Our ref: Alterations and additions to St Philip's Christian College Cessnock campus (SSD-10360337)

Subject: Request for Additional Information

I refer to the assessment of the proposed Alterations and additions to St Philip's Christian College Cessnock campus (SSD-10360337). The Department requires the following additional information to enable the continued assessment of the proposal:

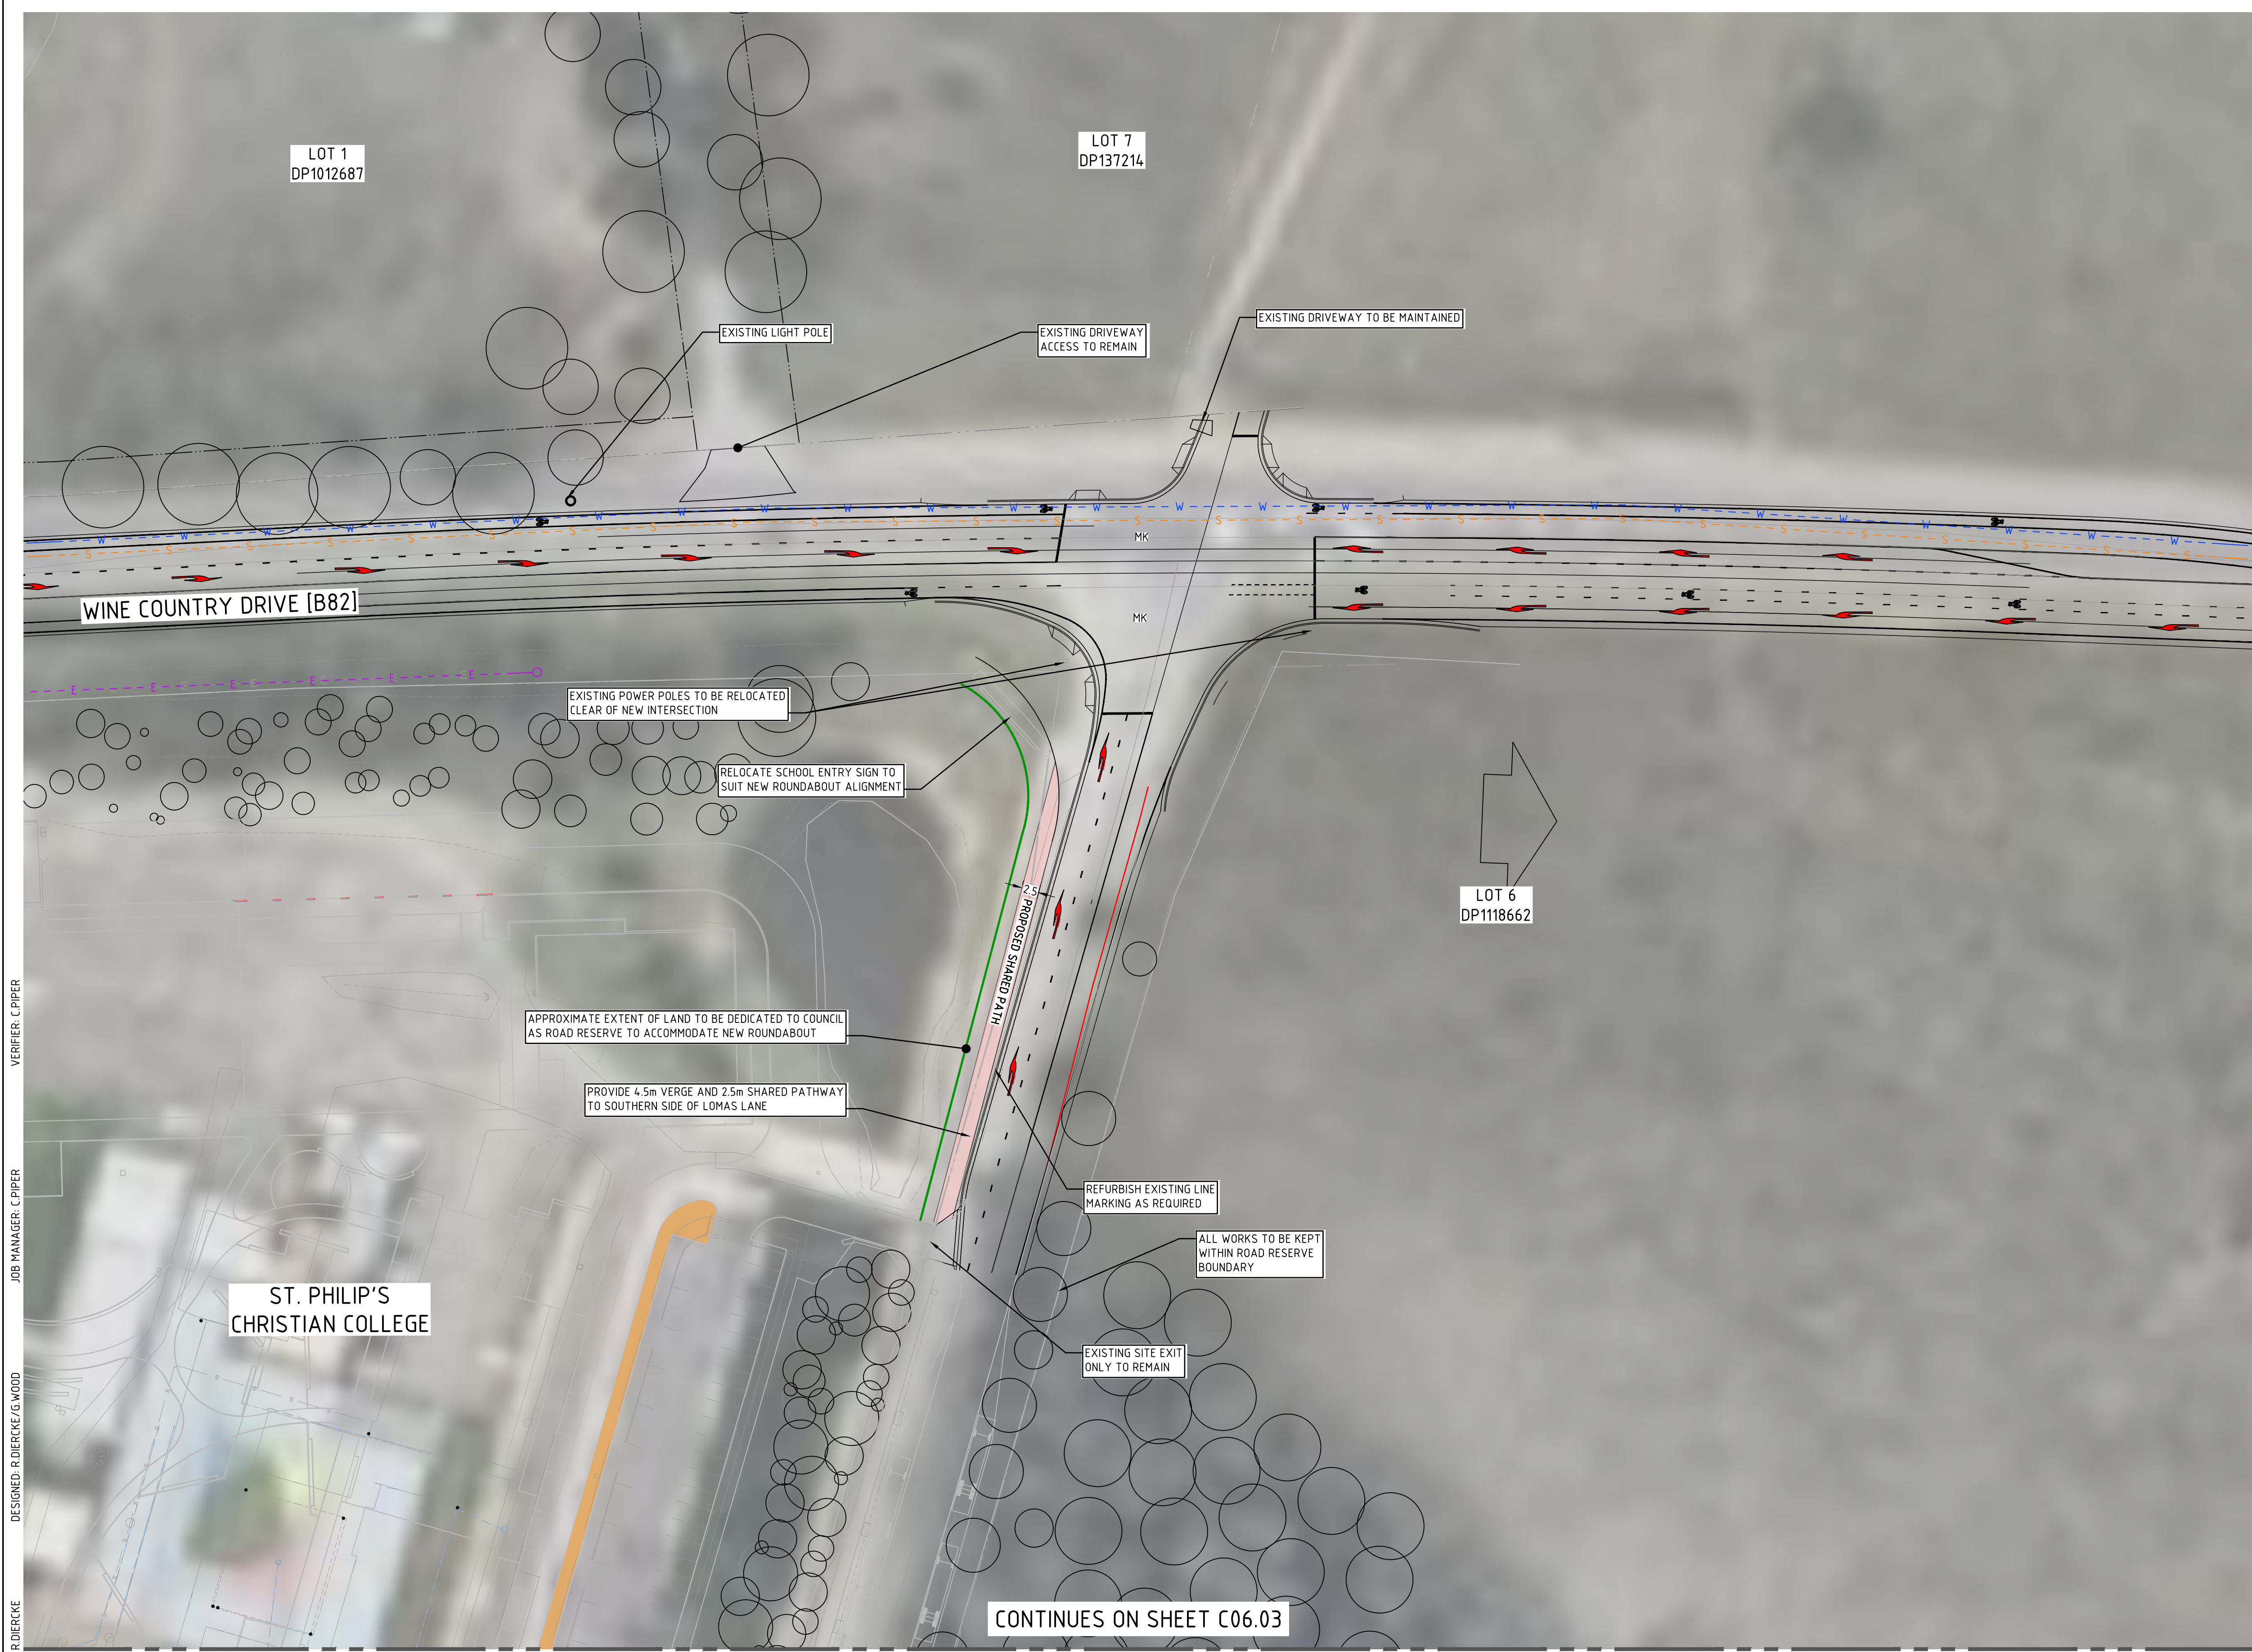
- The proposed new intersection works require the resolution of adjoining land owners driveway access to Wine Country Drive. The Department has consulted with TfNSW who have confirmed that the access arrangements would not be resolved through the WAD process and therefore must be resolved as part of this DA. To ensure appropriate access is achieved, a coordinated design outcome and improved traffic functionality, the Department therefore requires a clear description of all works proposed on adjoining properties as part of the intersection upgrade works, including plans, and scope of works. The Applicant is to demonstrate how the fourth leg of the intersection will connect to the existing driveways of both lot 1 DP 1012687 (No 305 Wine Country Drive) and Lot 7 DP 137214 (No 313 Wine Country Drive) any required driveway re-alignments and any required new or amended rights of way that need to be established to ensure appropriate access outcomes are achieved.

- The Department notes that the civil plans include notations showing the existing driveways on both lots to be retained. However, upon discussion with TfNSW, the Department has been advised that the existing driveway on 305 Wine Country Drive may not be able to be maintained in its current configuration and the existing driveway on 313 Wine Country Drive in close proximity of the intersection will not be able to be maintained at all. The civil plans require updating accordingly. Additionally, the Applicant is to provide detail arrangements of any proposed left-in left-out movements to the existing driveway no 305.
